**KIRKLEES METROPOLITAN COUNCIL  
INVESTMENT & REGENERATION SERVICE**

**DELEGATED DECISION TO DETERMINE PLANNING APPLICATIONS**

Reference No:	<b>2024/62/92923/W</b>
Site Address:	489, New Hey Road, Salendine Nook, Huddersfield, HD3 3XG
Description:	Erection of rear extensions, side porch, rear dormer extension and associated alterations
Recommending Officer:	Joanna Rednall

**DECISION – Full Conditional Permission**

Scale: 1:50 & 1:100	Drawing Number 2024/013/06	Rev. A	Date Drawn Oct. 2024	Drawn By Andrew Smith
------------------------	-------------------------------	-----------	-------------------------	--------------------------

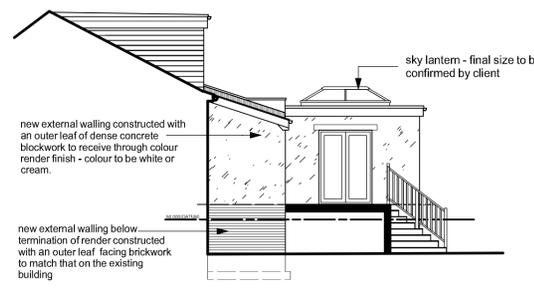
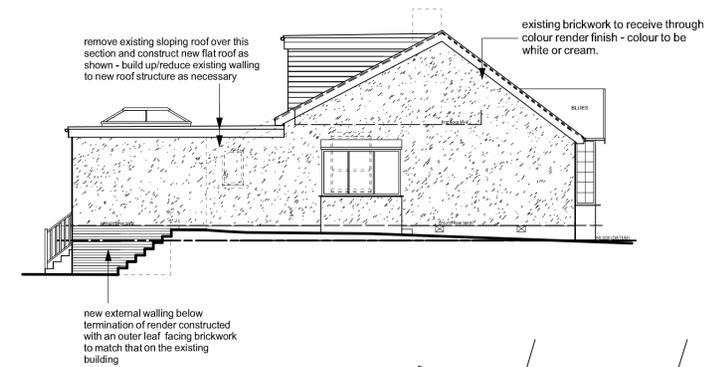
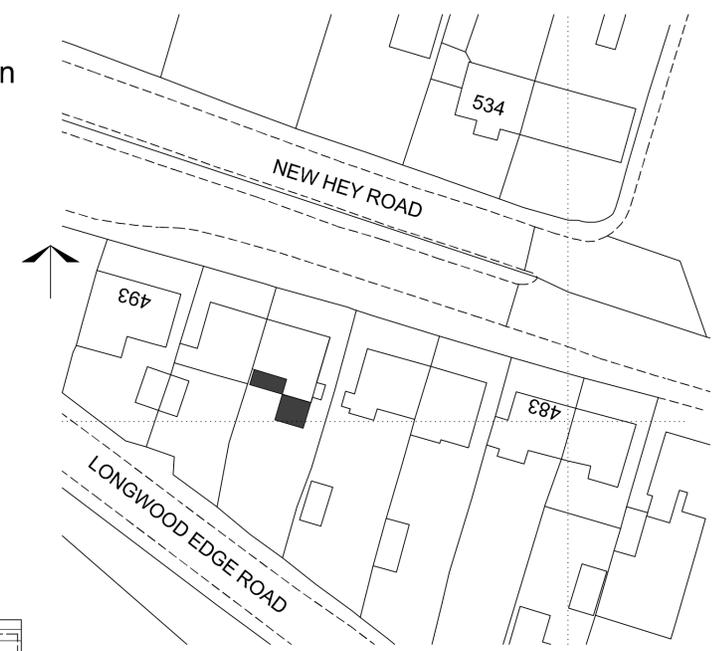
The raised area projects approximately 3 metres beyond the rear elevation of No.491. Given its elevated position within close proximity to the shared boundary, there is potential for undue overlooking / harm to the privacy of occupiers of No.491. The submitted plans indicate a 1.8m high privacy screen to the west-facing elevation, this is considered to sufficiently mitigate any undue overlooking impacts. A condition will be attached to the decision notice accordingly.

4. The raised patio hereby approved shall not be first brought into use until the 1.8 metre high obscurely glazed balustrade shown on the approved plan reference 2024/013/06 has been installed in complete accordance with the detail shown on that plan and to a grade 4 degree of obscure glazing. Thereafter, the obscurely glazed balustrade shall be retained in accordance with the details shown on the approved plan and the requirements of this condition.
